A428 Black Cat to Caxton Gibbet improvements

9.97 Applicant's Response to the Examining Authority's Third
Round of Written Questions

January 2022

Regulation Number	Rule 8(1)(b)
Planning Inspectorate Scheme Reference	TR010044
Document Reference	TR010044/EXAM/9.97
Author	A428 Black Cat to Caxton Gibbet improvements Project Team, National Highways

Contains OS data © Crown Copyright and database right 2020
Contains public sector information licensed under the Open Government Licence v3.0
© Natural England material is reproduced with the permission of Natural England 2020. NB Local Nature Reserve dataset is "indicative" not "definitive".

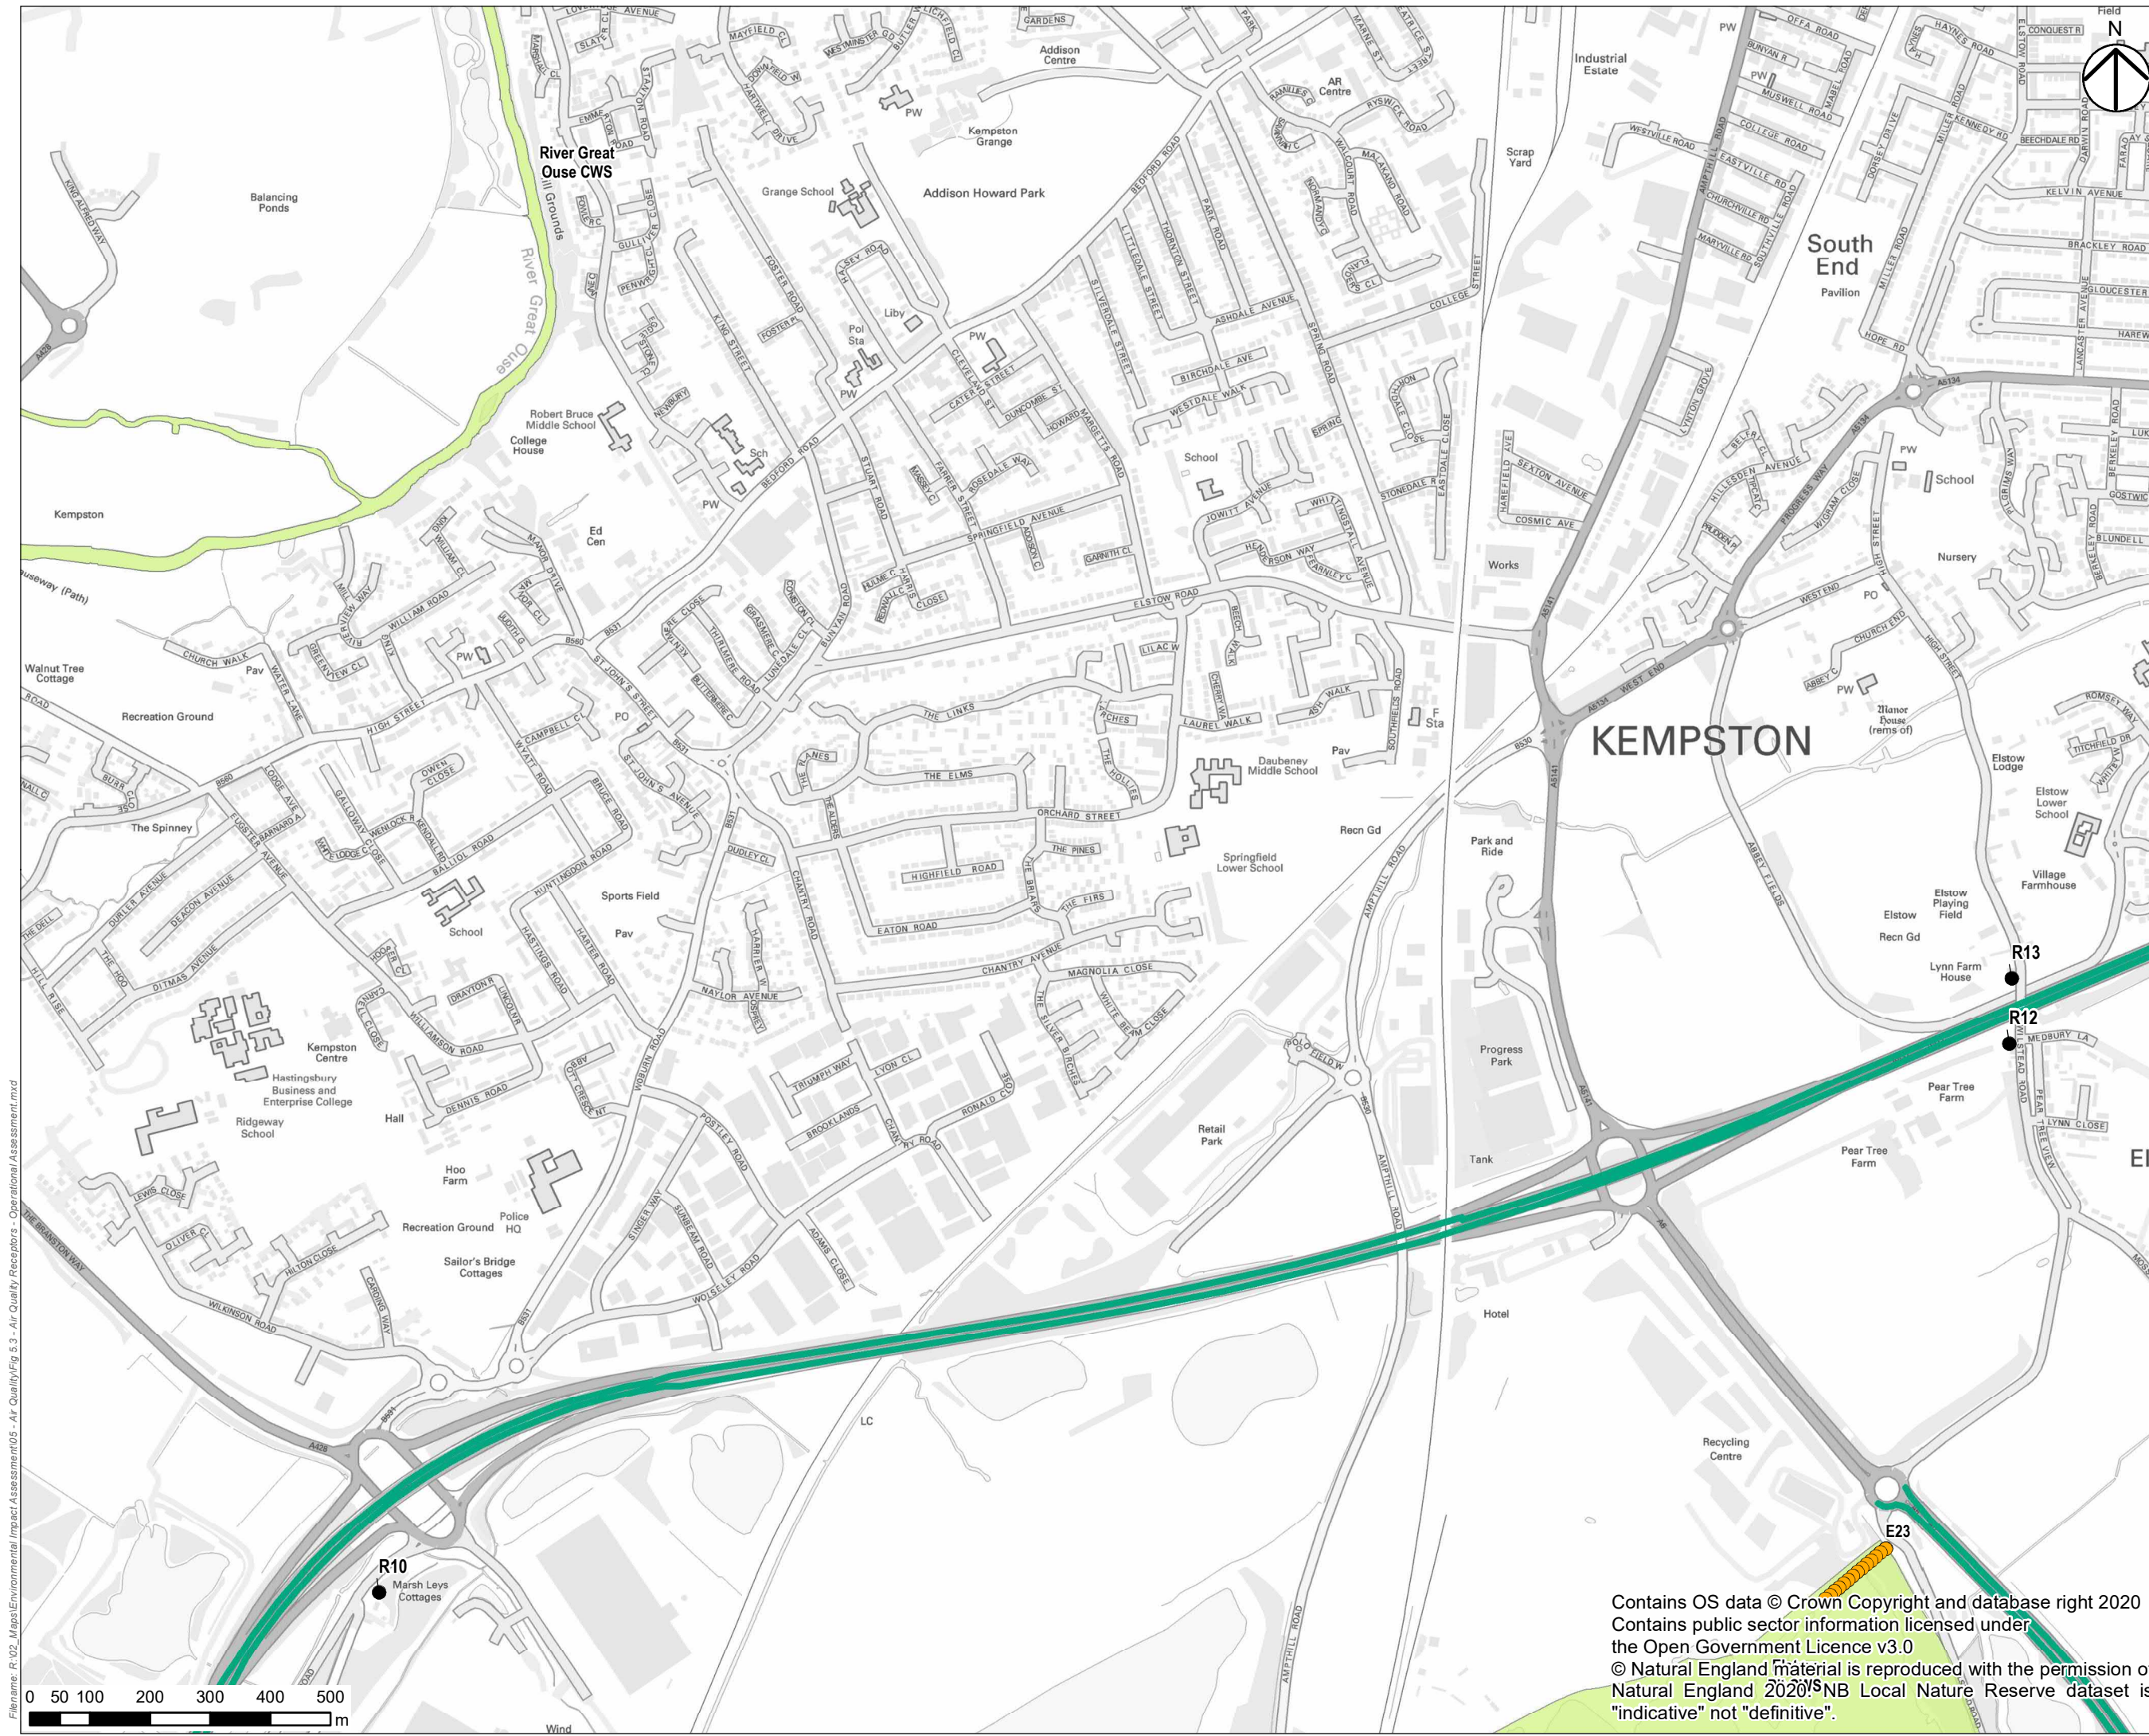
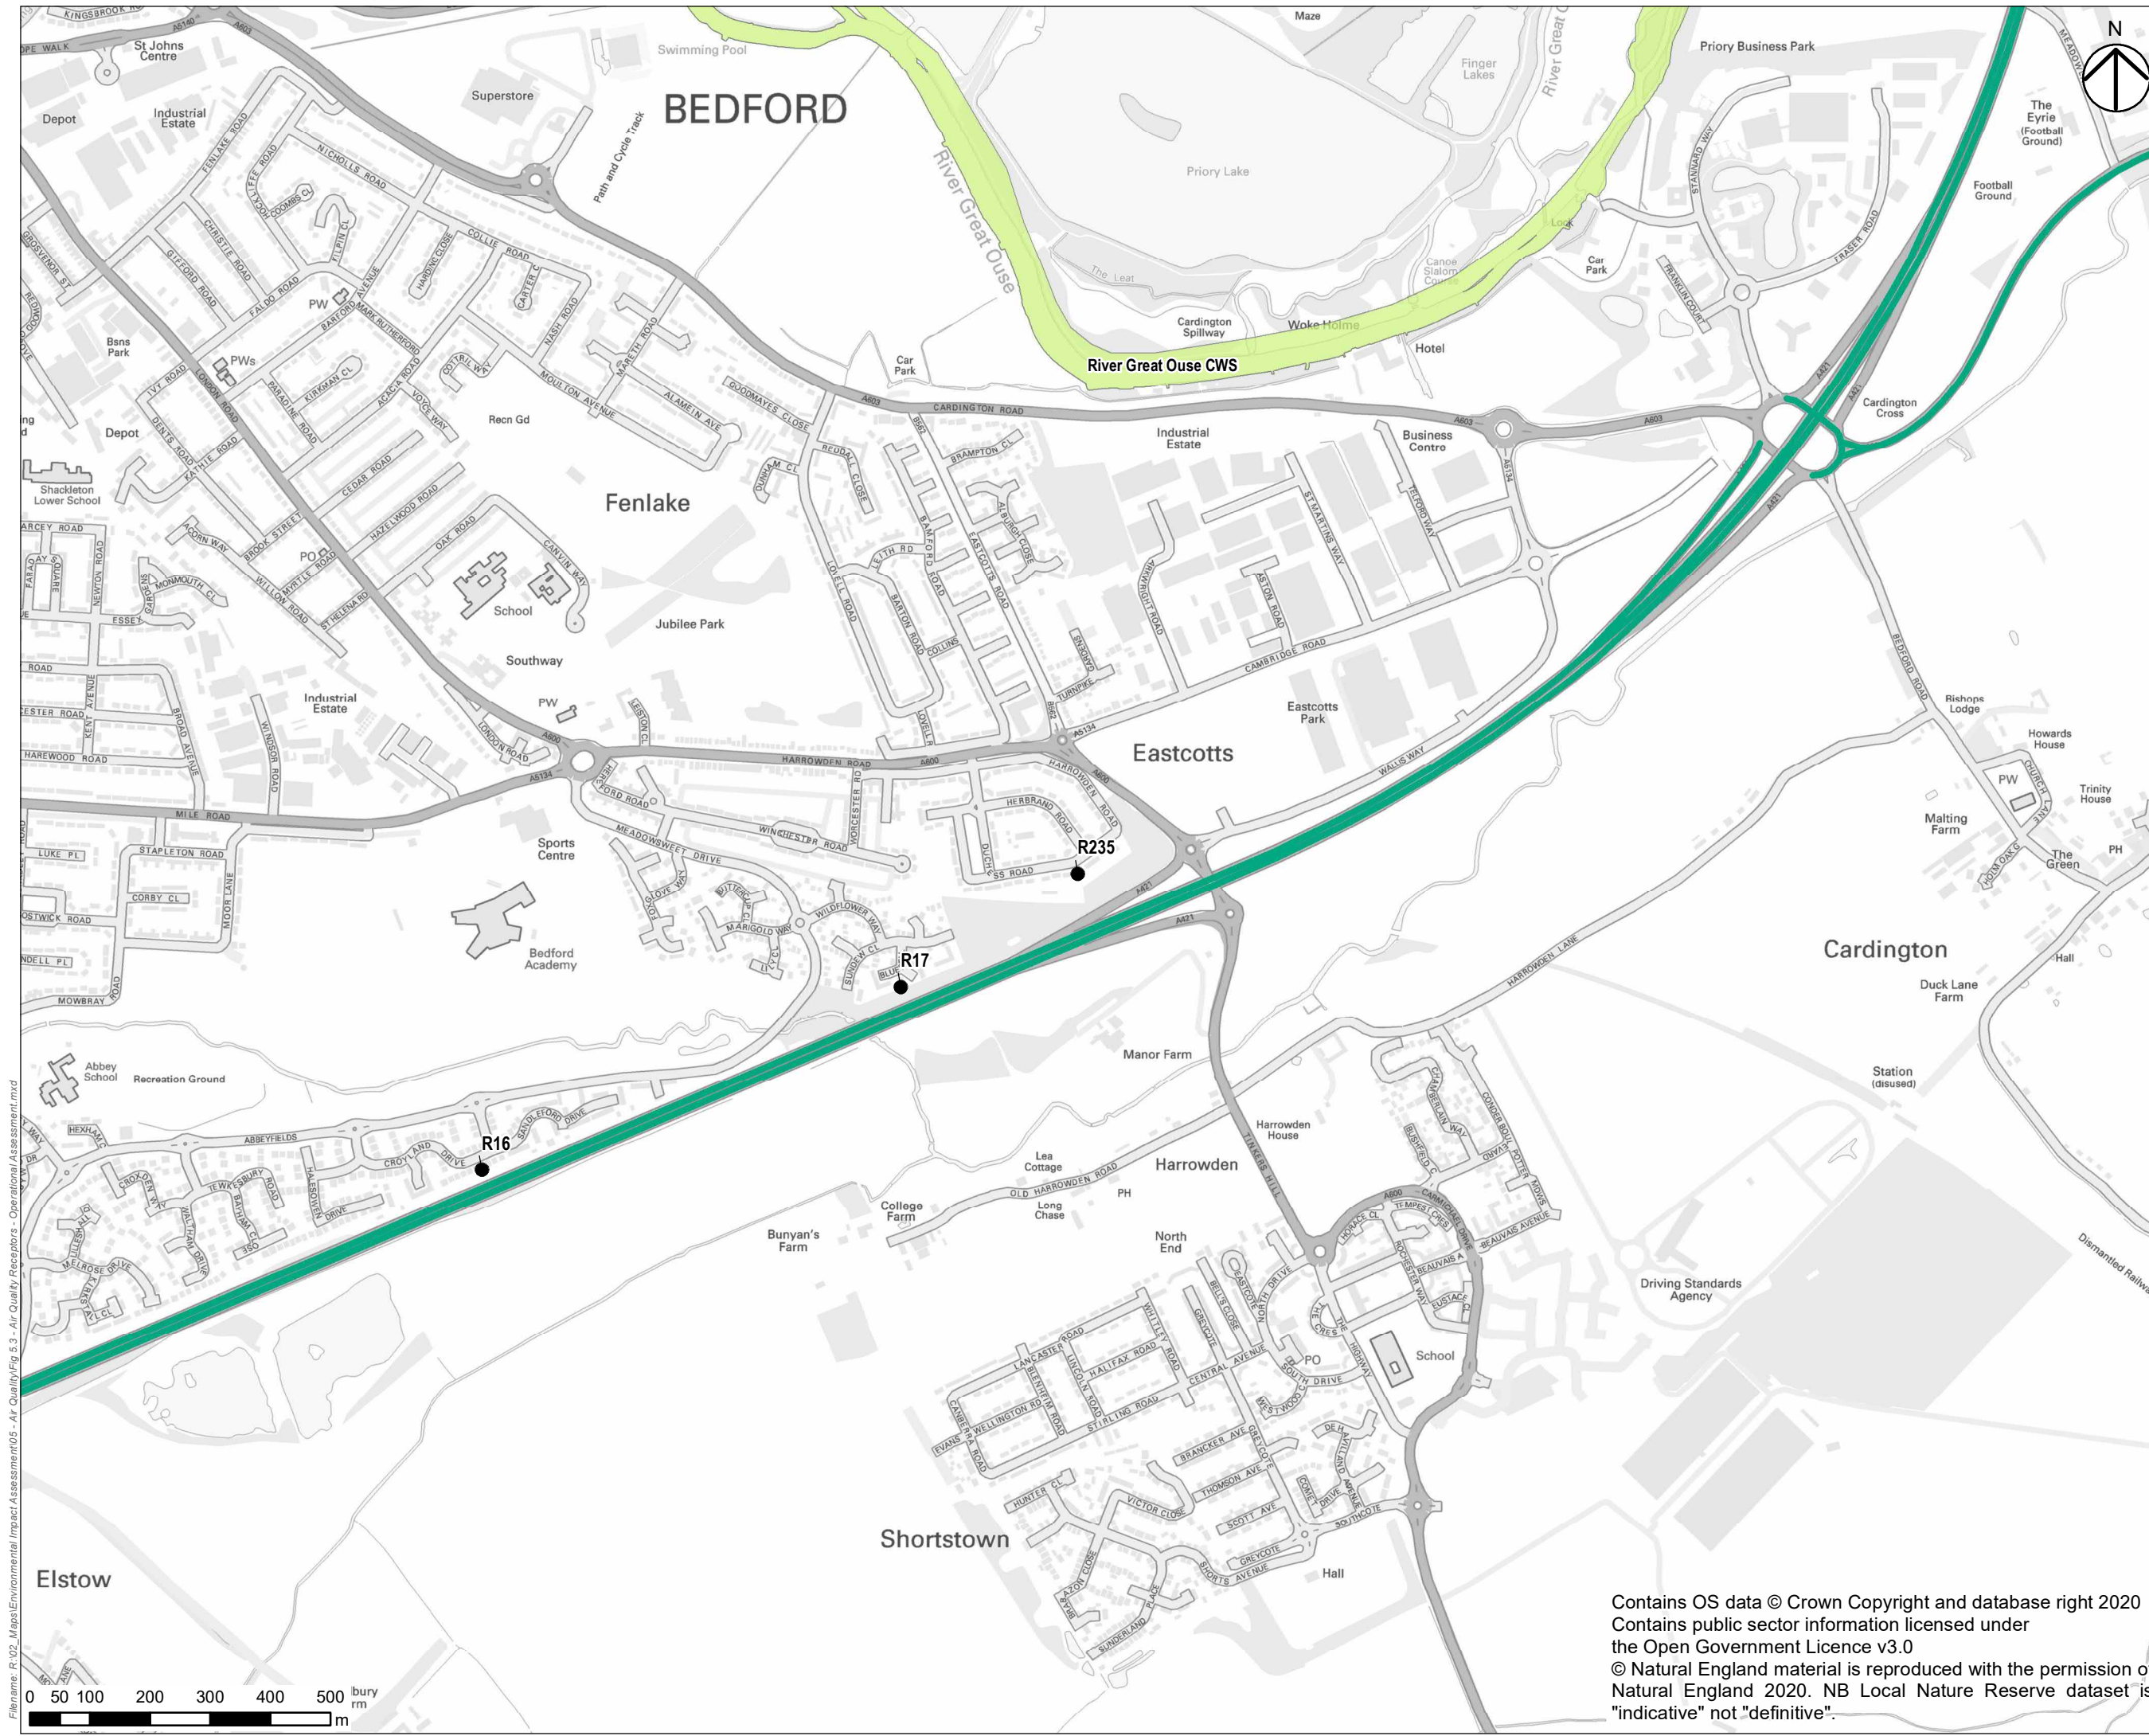
No.	Directed to	Question																							
		<p>As identified above, there are 7 properties within the Sandy AQMA where annual mean concentrations are predicted to be above the objective value for annual mean NO₂ in the Scheme opening year (with and without the Scheme in place). These properties are shown on Figure 5.4 (sheet 9) of the Environmental Statement (ES) [APP-096].</p> <p>To assist the Examination the Applicant has presented in Table 3.2.1.1-1 the highest and lowest predicted annual mean NO₂ concentration which covers the range of concentrations at these properties without (Do-Minimum (DM)) the Scheme and with (Do-Something (DS)) the Scheme. The predicted change is the same at each property. The table presents the predicted concentrations reported in Chapter 5 of the ES [APP-074] and the same data projected to 2026.</p> <p>Table 3.2.1.1-1: Predicted NO₂ Concentrations from the ES and Projected Concentrations</p>

<p data-bbox="654 981 1852 1077"><i>Note: Predicted change is calculated from unrounded predictions. Values rounded to 1 decimal place for presentation.</i></p> <p data-bbox="654 1077 2132 1204">This shows that based on these projections a 1% increase (0.4 µg/m³) is removed within a year with projected reduction in concentrations of between 0.7-0.8 µg/m³ from the opening year to the following year, with the projected Do-Something concentration in 2026 being below the predicted Do-Minimum concentration in 2025.</p> <p data-bbox="654 1204 2132 1284">As a change of this magnitude would be removed within 12 months a significant effect does not arise for the purposes of para 5.12 of the National Policy Statement for National Networks (NPS NN).</p> <p data-bbox="654 1284 2132 1332"><i>CBC Air Quality Action Plan Mitigation Measures</i></p> <p data-bbox="654 1332 2132 1399">CBC have submitted into the Examination their Air Quality Action plan measures [Appendix 7, REP1-055], one of which is the introduction of average speed cameras along the A1 in Sandy AQMA and another was the reduction in</p>	Receptor	2025 (ES Predictions) (µg/m ³)			Projected concentrations 2026 (µg/m ³)		DM	DS	Change	DM	DS	R222	52.5	52.7	+0.2	51.8	52.0	R286	58.0	58.3	+0.2	57.2	57.5
Receptor	2025 (ES Predictions) (µg/m ³)			Projected concentrations 2026 (µg/m ³)																					
	DM	DS	Change	DM	DS																				
R222	52.5	52.7	+0.2	51.8	52.0																				
R286	58.0	58.3	+0.2	57.2	57.5

No.	Directed to	Question
		<p>speed limit to 40mph. In regard to the Sandy AQMA specifically, National Highways have previously discussed possible measures with CBC.</p> <p>The potential for average speed cameras to be installed along this section of the A1 had been initially identified primarily as a potential safety measure and National Highways had given consideration as to whether this might offer any air quality benefits. The consideration of average speed cameras was not put forward as a sole means to deliver air quality benefits rather it would have been explored had the average speed cameras been delivered as part of the safety case. It has now been determined by National Highways that there is not a safety requirement for average speed cameras along this route and National Highways is not aware of any evidence that would suggest the use of average speed cameras here would improve air quality in this location.</p> <p>National Highways commissioned a consultancy firm, Connected Places Catapult to undertake an analysis of changes in emissions from Light Duty Vehicles^[3] (cars and vans) under different driving conditions and different speed limits. The analysis set out in the report demonstrated improvements in NO_x emission rates could be identified when reducing the speed limit from 70mph to 60mph (average approx. 17% reduction in emissions compared to 70mph). No further improvements were identified with a reduction to 50mph (average approx. 15% reduction compared to 70mph).</p> <p>The section of the A1 past the receptors identified in the air quality assessment with annual mean concentration of NO₂ predicted to be above the UK Air Quality Strategy objective of 40µg/m³ already has a speed limit of 50mph. A reduction in speed here to 40mph would not be anticipated to lower vehicle emissions or consequently lead to a reduction in NO₂ concentrations. This is because emissions of pollutants from vehicles vary with speed and the lowest emissions are around 40-60mph, therefore further reductions in speed are not considered likely to improve emissions as very similar emissions are expected around these speeds. This is consistent with the emission rates in Defra's Emissions Factors Toolkit (EFT) and the DMRB speed banding tool.</p> <p>In their response to WQ2, Q2.2.1.1 [REP4-062] CBC refer to studies carried out in other areas that show a permanent speed restriction of 40mph is beneficial for air quality compared to 50mph. The Applicant has requested these studies from CBC (via email 11 Nov 2021) in order to consider the potential for a beneficial effect on Sandy outside of this DCO Examination. This is because the assessment for the Scheme has concluded that it does not trigger a significant air quality effect, as explained above, and therefore mitigation measures are not required. A copy of this study has not been provided by CBC to the Applicant at this time. The Applicant will review these studies once received and seek opportunities to support CBC, potentially through Designated funds.</p>
